Reference No:	2023/62/93088/W
Site Address:	Hunters Lodge, Cemetery Road, Holmfirth, HD9 2RH
Description:	Erection of two storey side extension
Recommending Officer:	William Simcock

DECISION – Conditional Full Permission

Officer Report 2023/93088
Hunter's Lodge, Cemetery Road, Holmfirth

SIDE (SE) ELEVATION

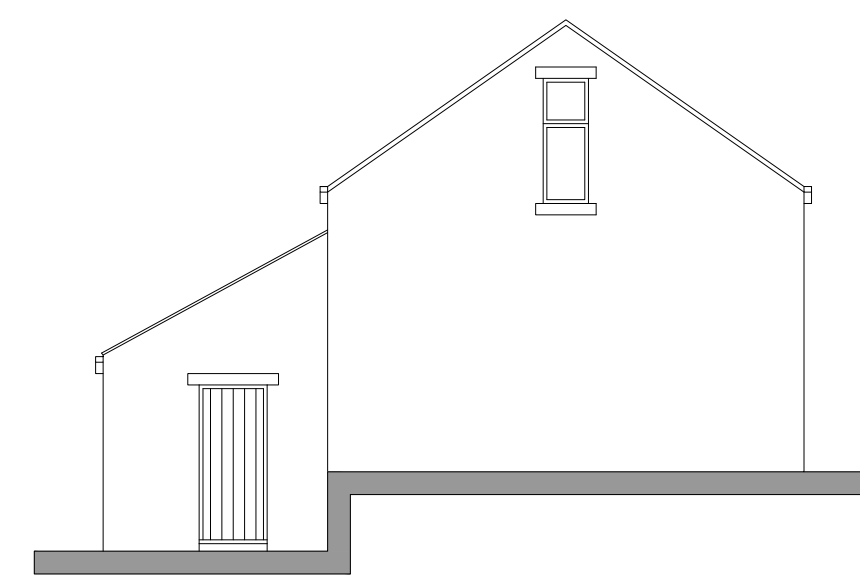
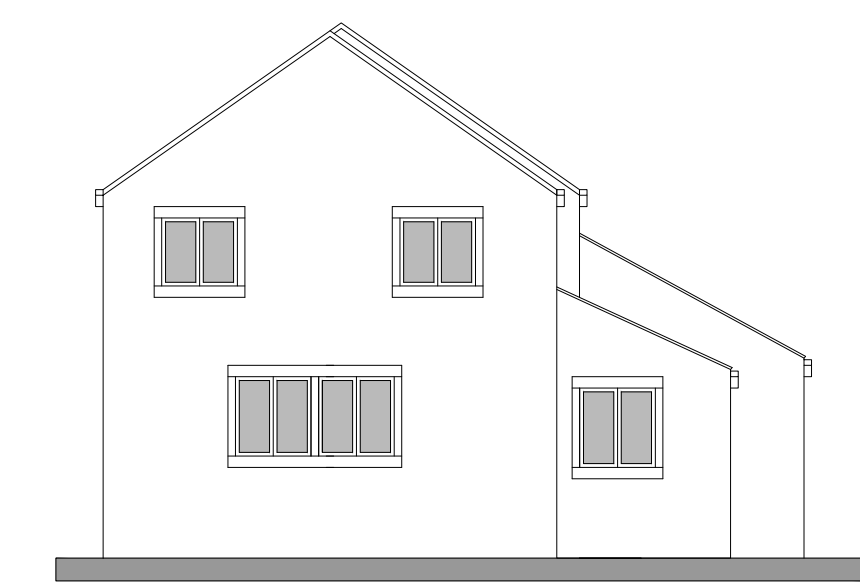
A single-storey extension that originally formed part of the proposals has been deleted.

05-Dec-2023 – The single-storey element was deleted from the proposal and the two-storey element retained.

The scheme as originally submitted involved an extension to the front, and it is considered that based on the architect’s own figures, this would have given rise to a disproportionate addition. Now that the proposal is being assessed as for a two-storey side extension only, it is no longer considered disproportionate. It would allow the existing building to remain the dominant element both in size and in appearance. The increase in volume is now reduced to a 30.9% increase, just the side extension, or 36.6% with the porch. This would not amount to a disproportionate addition to the original dwelling and the application therefore fully accords with national and local planning policy.

client	MR A NUTTON		
project	PROPOSED EXTENSION TO HUNTERS LODGE, CEMETERY ROAD, HOLMFIRTH		
drawing	PROPOSED PLANS AND ELEVATIONS		
revision	notes	date	drawn
A	SINGLE STOREY EXTENSION OMITTED	12.23	PB
scale :	1:50 & 1:100 AT A1	11.22	PB
project no.	drawing no.	revision	
2246	02	A

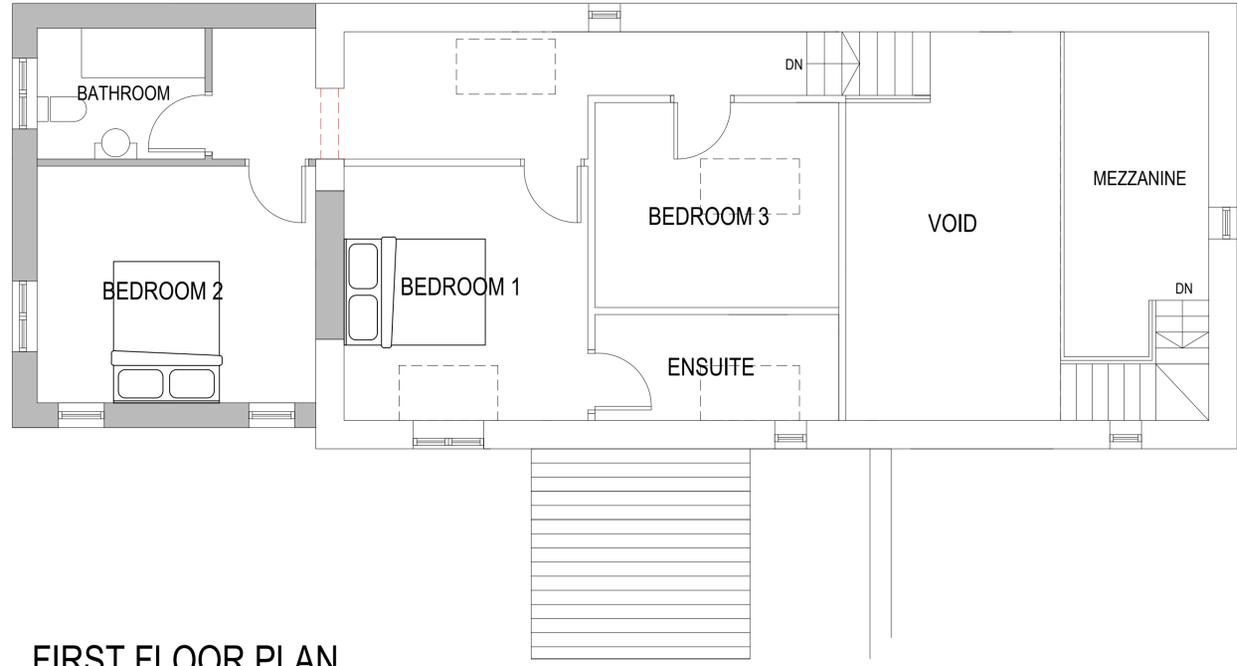
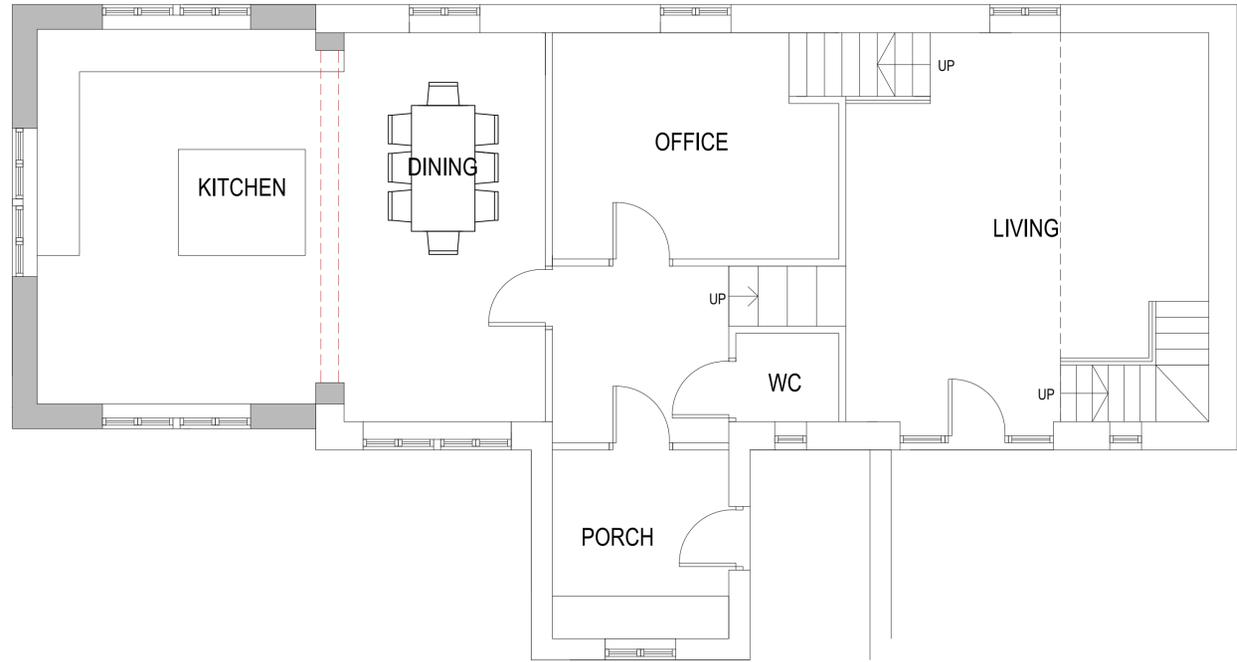
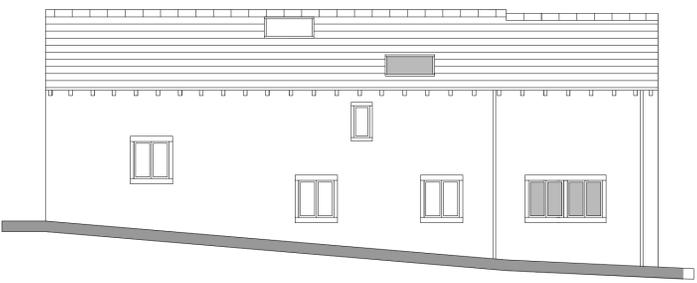
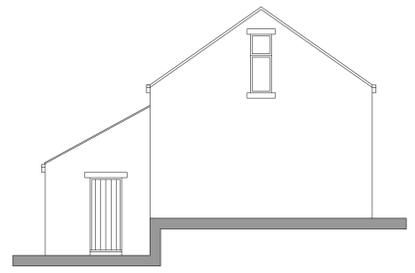
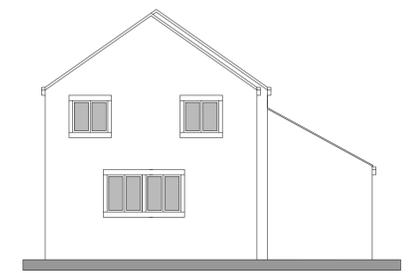
As drawn, the two-storey extension does not comply with part 5.3 of the SPD which requires a 500mm setback as standard. It is considered that in this instance, as the dwelling does not face directly on to the adopted highway or form part of a built-up row, a setback of 300mm with the slight break in the roofline, is sufficient to ensure that it respects the appearance of the host building and its surroundings, and the departure from published standards is justified in this instance.

Design details, including the fenestration and the use of corbels, would respect the vernacular character of the former barn.

3. The external walling and roofing materials shall in all respects match that used in the construction of the existing building.
